A1 in Northumberland TR010059

### **Northumberland County Council's Relevant Representation**

#### **Relevant Representation of Northumberland County Council under Section 56 of the Planning Act 2008 in respect of the A1 in Northumberland Development Consent Order Application.**

**Trees to be Removed and Replaced at Coronation Avenue  
WQ LV.1.8**

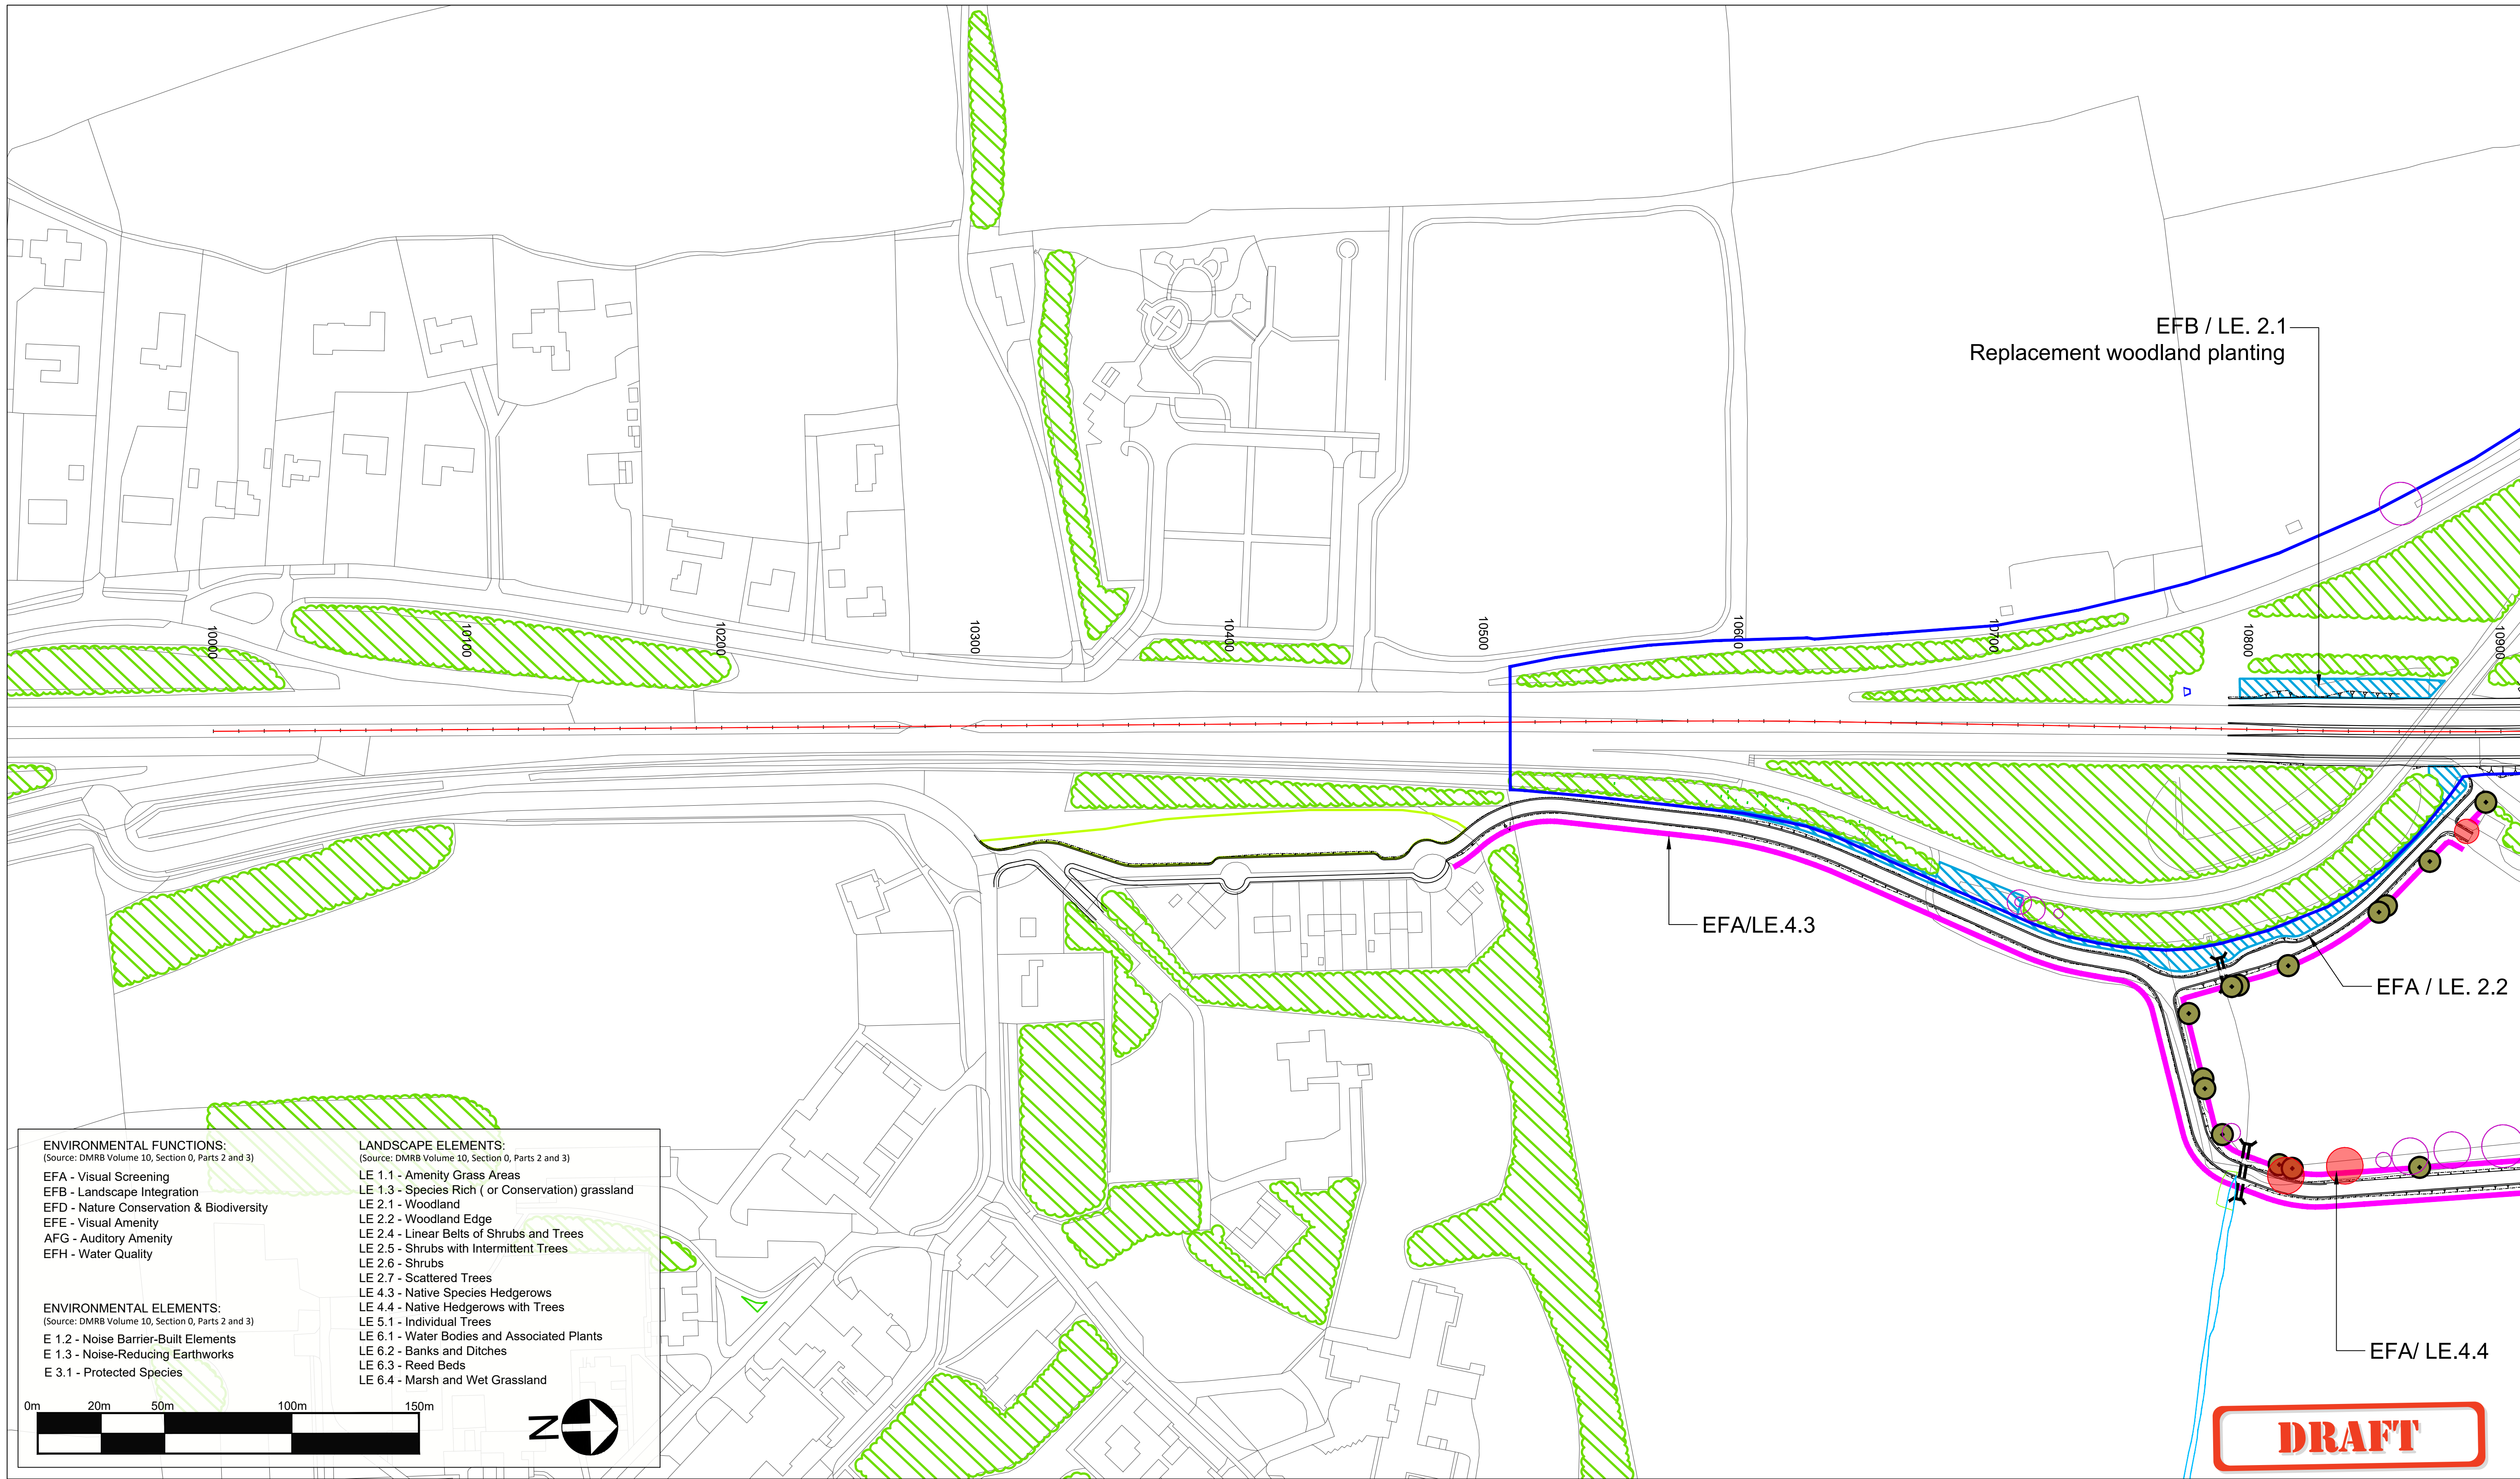
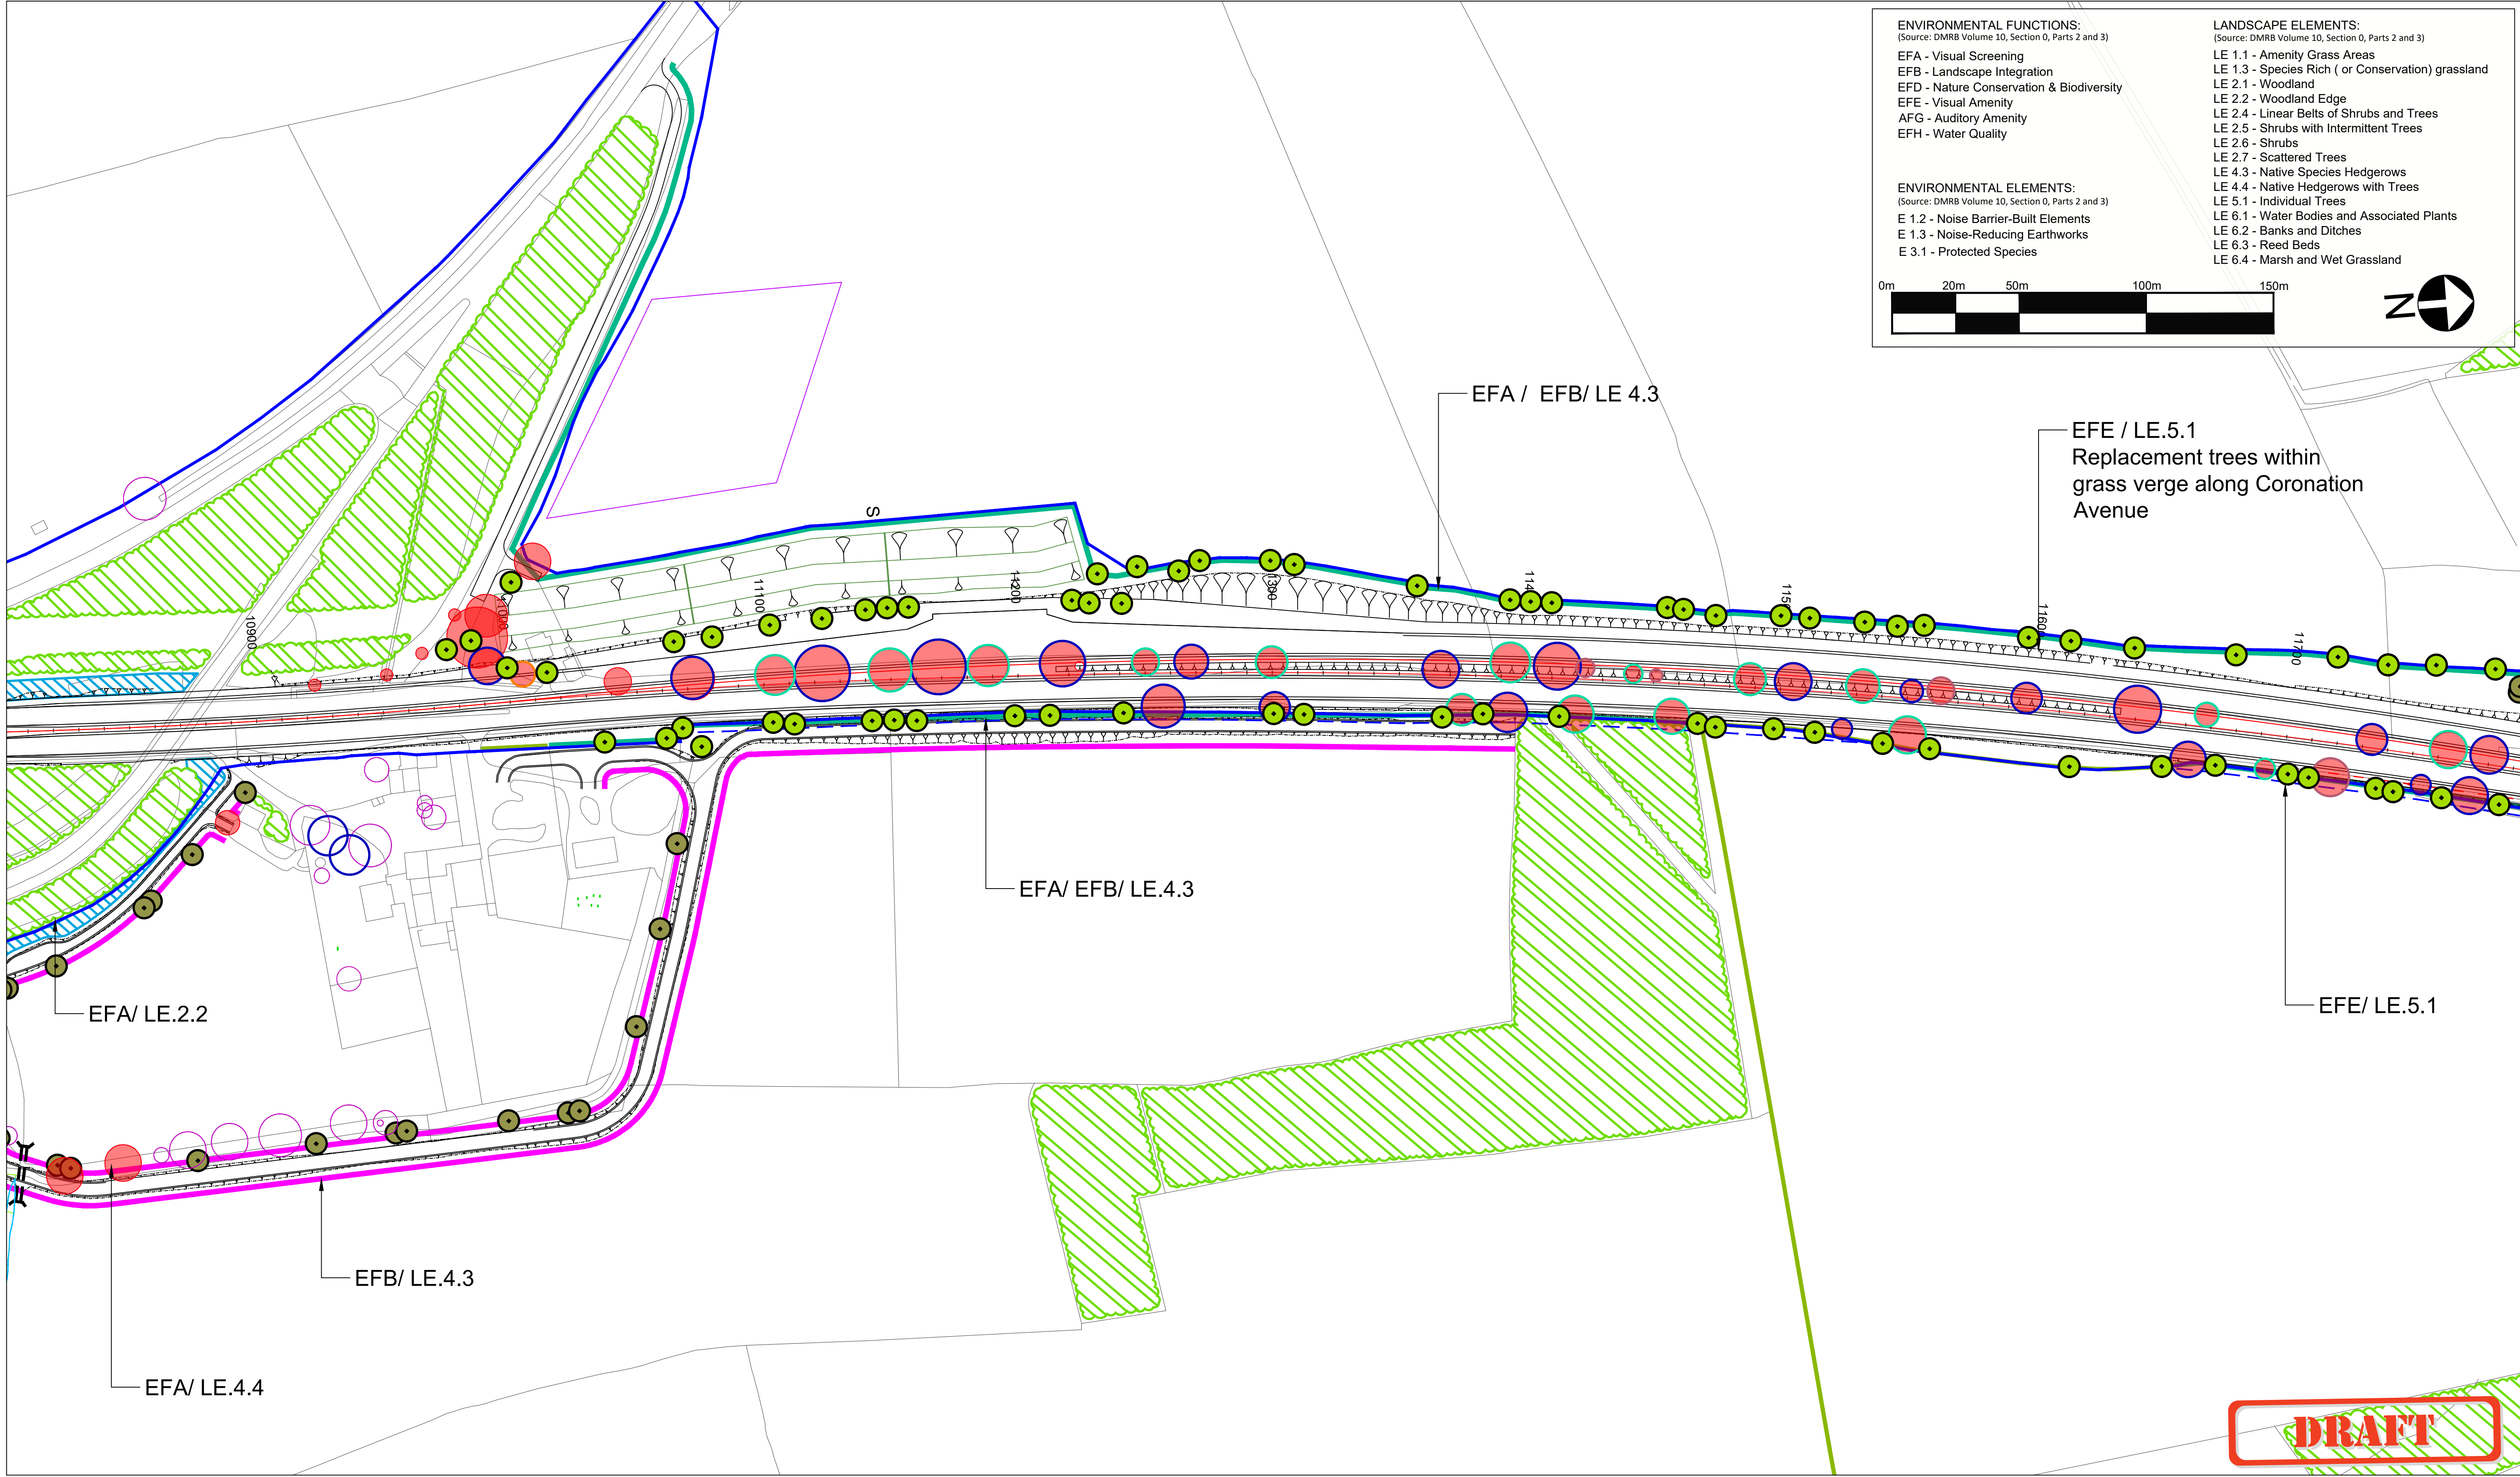
23. The replacement Coronation Avenue is a token gesture, consisting of trees spaced roughly every 100m. This avenue plays an important role in retaining a rural, well-vegetated character through this section of the route and the LVIA is quite clear about the local importance of the Avenue as a landscape feature and the sparse nature of the replacement compared to what is removed is not explained or justified in the application.

24. There is a lack of certainty and commitment in the landscape proposals, some of the bunds are described as 'desirable mitigation' and it is unclear as to whether they will be delivered or not. A number of the proposed hedgerows are marked as being 'by agreement' and the replacement avenue is described as 'currently proposed' and 'as appropriate and if required' suggesting that these elements are not a committed aspect of the proposals.
